CITY OF MERCER ISLAND

October 15, 2018

RE: Review Comments for File No. CAO17-010 – Hou Critical Areas Determination
4825 E Mercer Way, Mercer Island, WA 98040; King County Tax Parcel # 216200-0070

**CRITICAL AREAS MITIGATION PLAN
 PROPOSED SITE PLAN, IMPACTS & MITIGATION PLAN
 HOU PROPERTY
 MERCER ISLAND, WA**

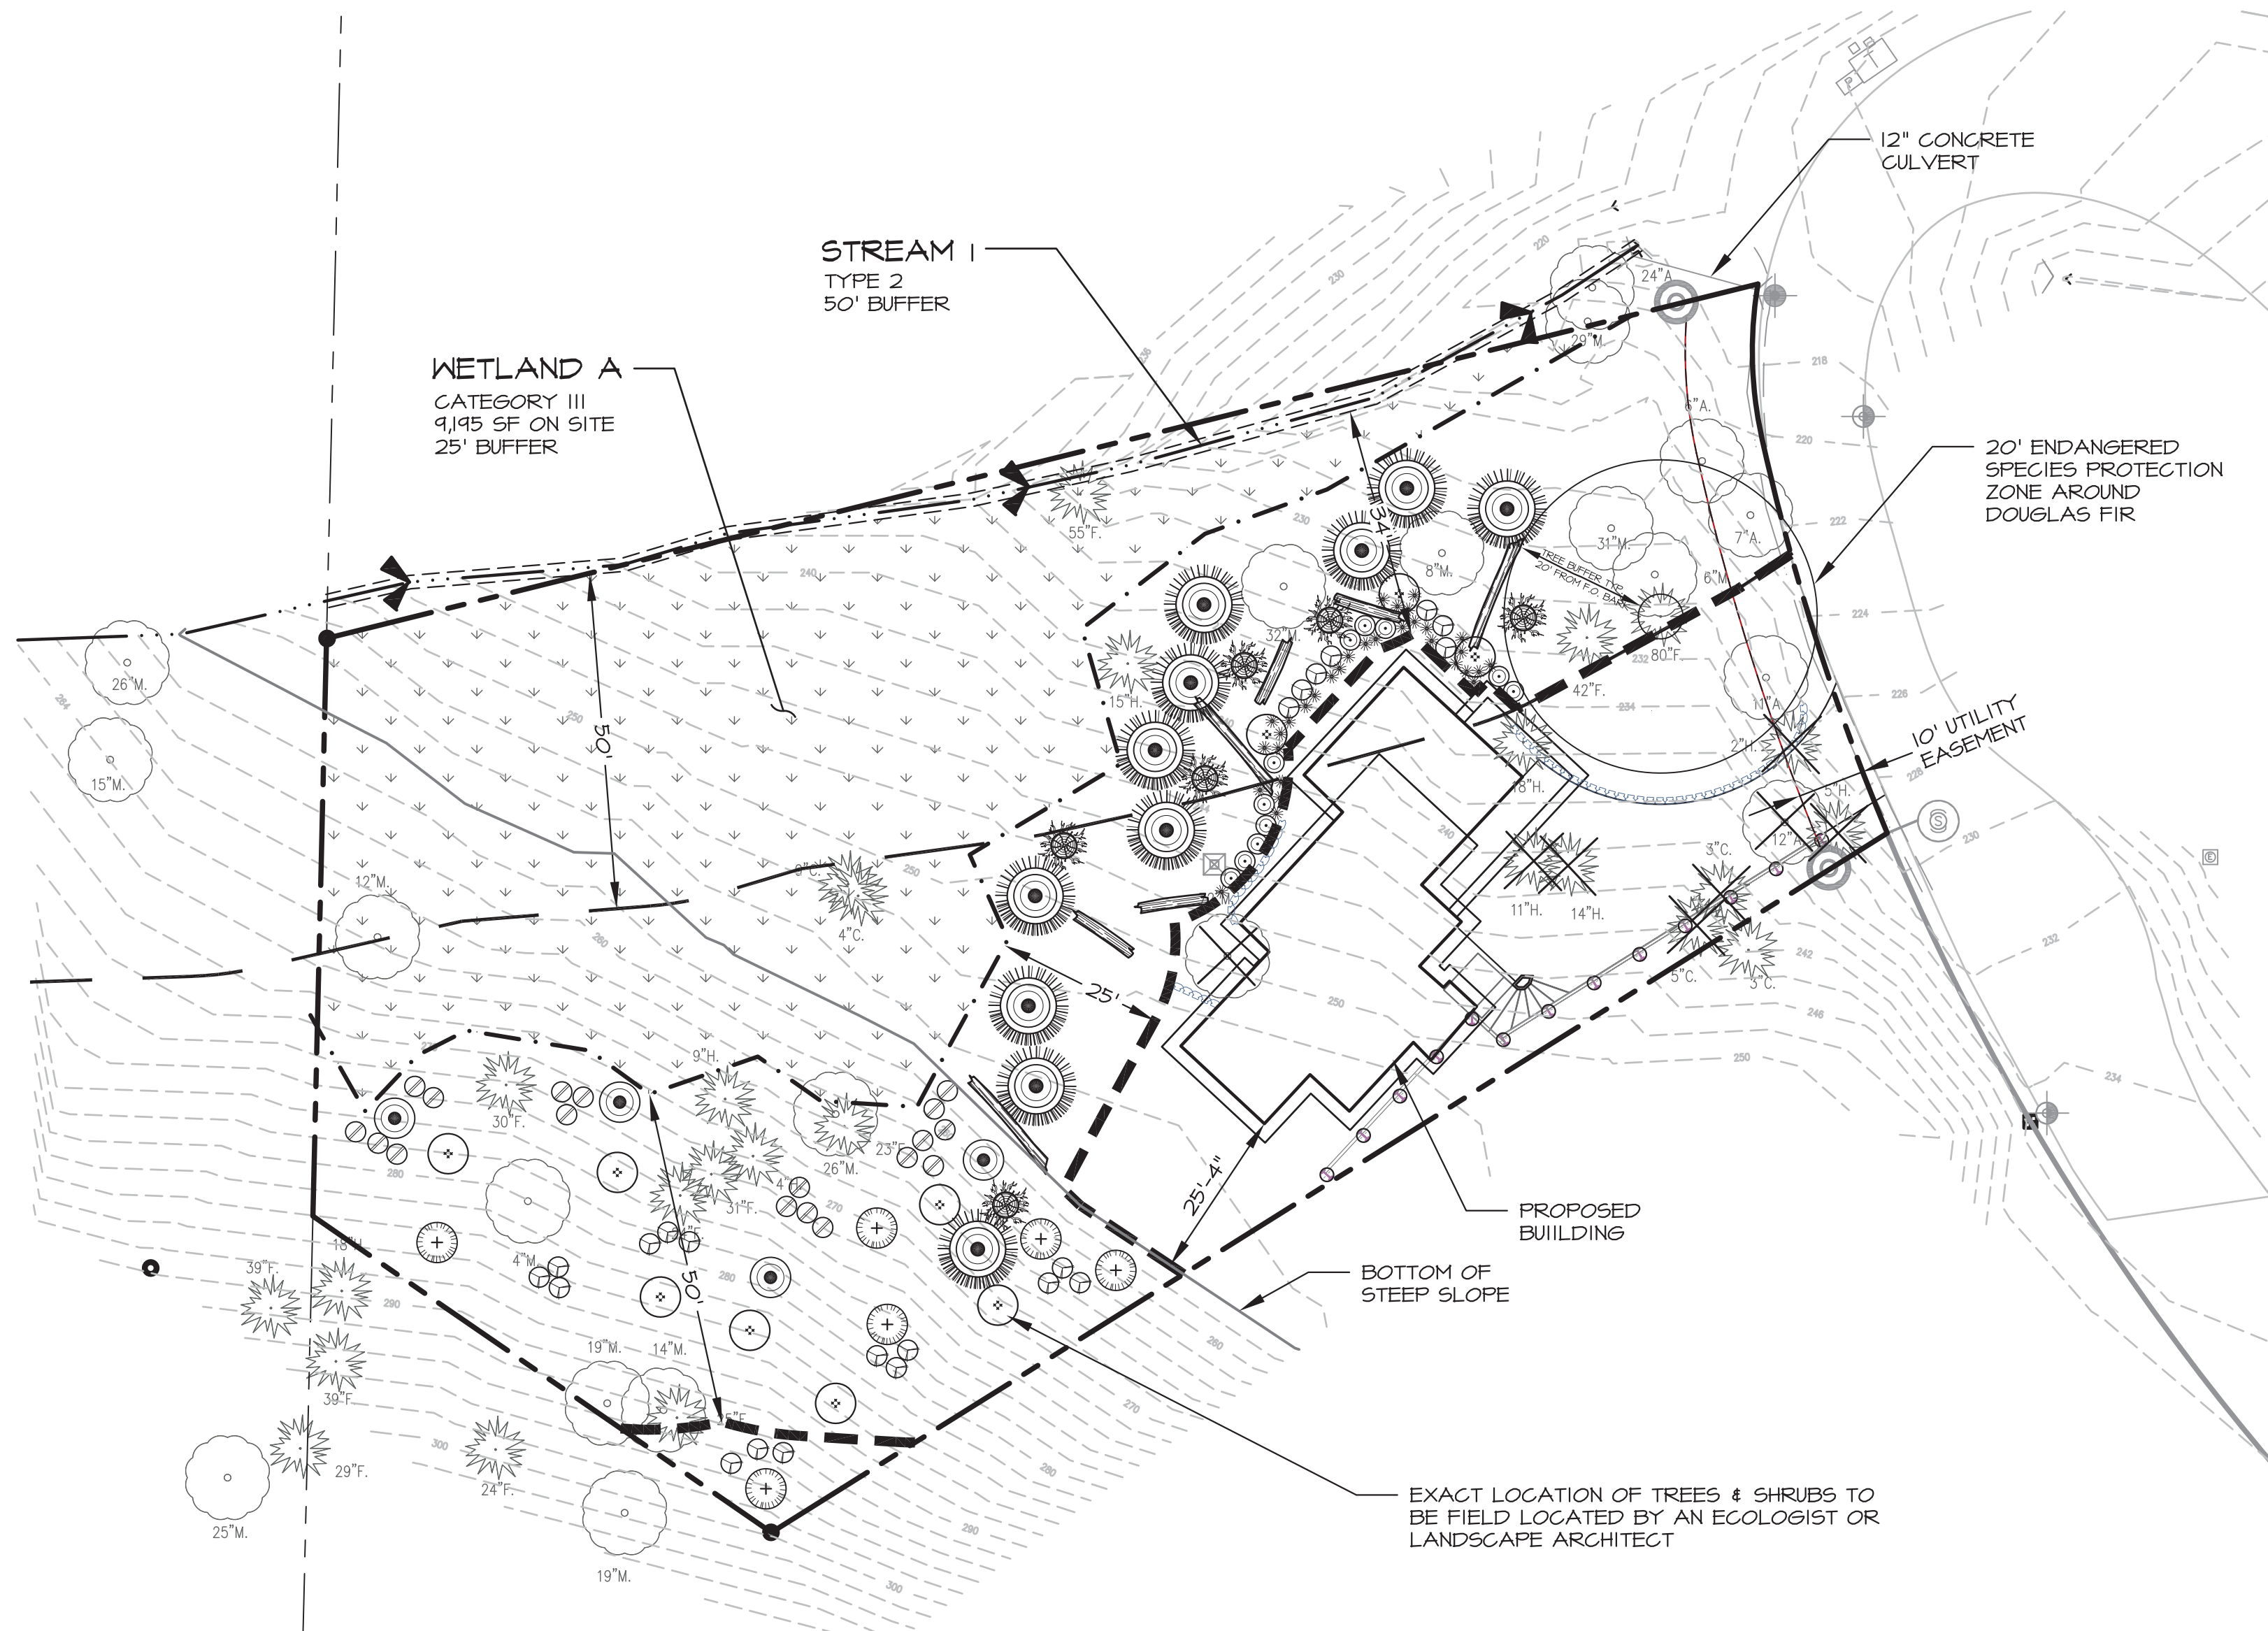
1. Please submit a revised Critical Area Report and Mitigation Plan that incorporates a 5-year monitoring period and associated standards for Years 1 through 5 to comply with MICC 19.07.
2. Pursuant to MICC 19.07.080(C)(2), buffer widths can only be reduced if the reduced area is adequate to protect wetland functions and the reduction will result in no net loss. Any harm to the trees may result in net loss due to the habitat benefits currently provided by the trees. Please ask your arborist to review the proposed encroachments to the drip lines of Exceptional Trees 916 and 917 as reflected Table 1 Summary of Drip Line Encroachments and provide a report stating that the proposed encroachments will not harm the trees.
